**RE: Response to Submissions – MP 05\_0147 MOD 12 – Modification to Project Approval – Enfield Intermodal Logistics Centre**

Thank you for your correspondence of 16 December 2016 which provided the last of the submissions for Modification 12 (MP05\_0147 MOD 12) to the Project Approval for the Enfield Intermodal Logistics Centre (Enfield ILC).

**Attachment A – Response to Submissions**

Figure 2 Enfield ILC Site Showing Assessment Locations

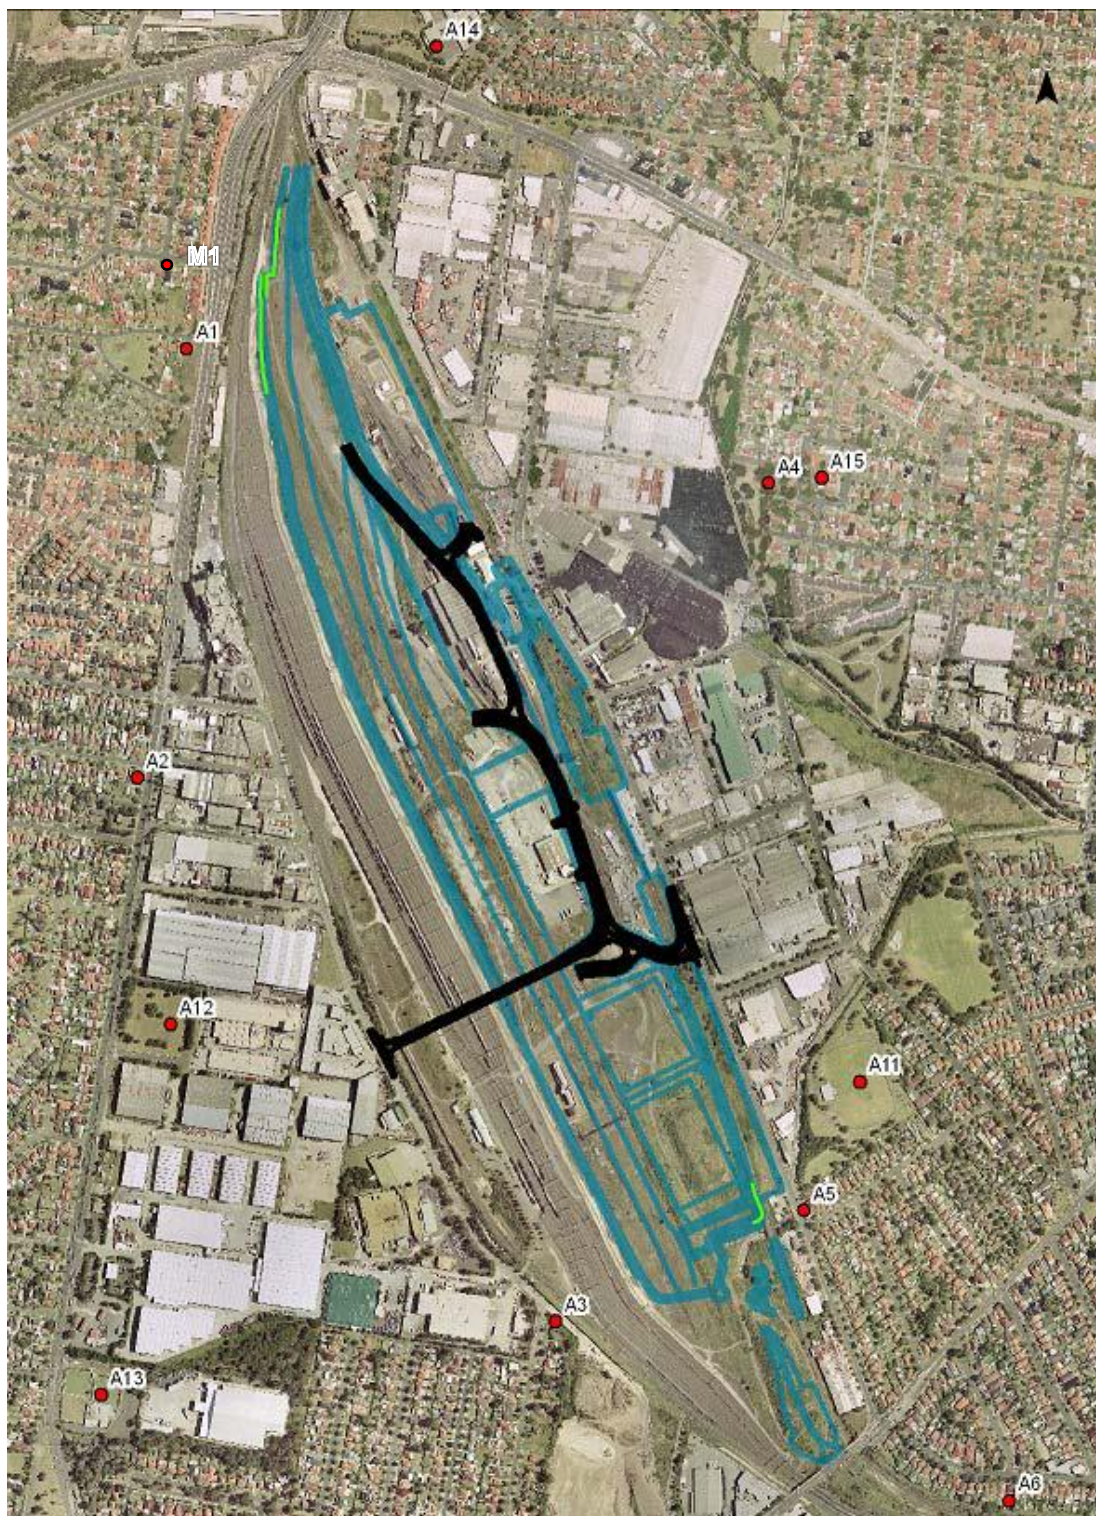
Strathfield Council: <ul style="list-style-type: none"> <li>Acoustic impact during construction and operation.</li> <li>The acoustic assessment report finds that noise levels during construction may exceed the relevant noise criteria at 2 Wentworth Street and at the western end of Blanche Street.</li> <li>Council requests that residents in the affected areas be given reasonable notification of works that exceed the noise criteria, their duration, total building time, provisions for minimising noise at</li> </ul>	<p>Construction:</p> <ul style="list-style-type: none"> <li>The Noise Impact Assessment (NIA) states in relation to construction noise that: <i>"In practice, the noise levels are likely to vary due to the fact that plant would move about the worksites and would not all be operating concurrently at all times. As such, noise levels are likely to be lower than the worst-case noise levels presented in [the NIA] for most, and probably all, of the time during the works."</i></li> <li>NSW Ports will notify affected residents of works that may potentially exceed the noise criteria, their duration, total building time, provisions for minimising noise at these times and notice of when respite periods will occur. Notifications will include a contact point for complaints.</li> <li>The CEMP, including the Construction Noise Management Plan, addresses the potential impacts of rail construction works. The proposed works will be undertaken in accordance with this Plan.</li> </ul> <p>Operation:</p>

<p>these times and notice of when respite periods will occur. Notifications should also include an accessible contact point for complaints.</p>	<ul style="list-style-type: none"> <li>Noise modelling was undertaken for the Noise Impact Assessment (NIA), with the adopted scenarios (being modified and refined scenarios from previous assessments) including consideration of train shunting activities associated with the proposed rail siding extensions.</li> <li>The NIA that was prepared for the proposed modification concluded that it is unlikely that there would be any exceedance of the operational noise limits identified in the existing conditions of approval.</li> <li>The NIA finds that the main noise contributor to proposed MOD 12 operational noise levels is from the movement and operation of reach stackers on the site. However, MOD 12 does not propose to increase the number of reach stackers nor change the locations in which they operate. All-be-it, reach stackers would operate slightly further away from sensitive receivers south west of the ILC as a result of MOD 12.</li> </ul>
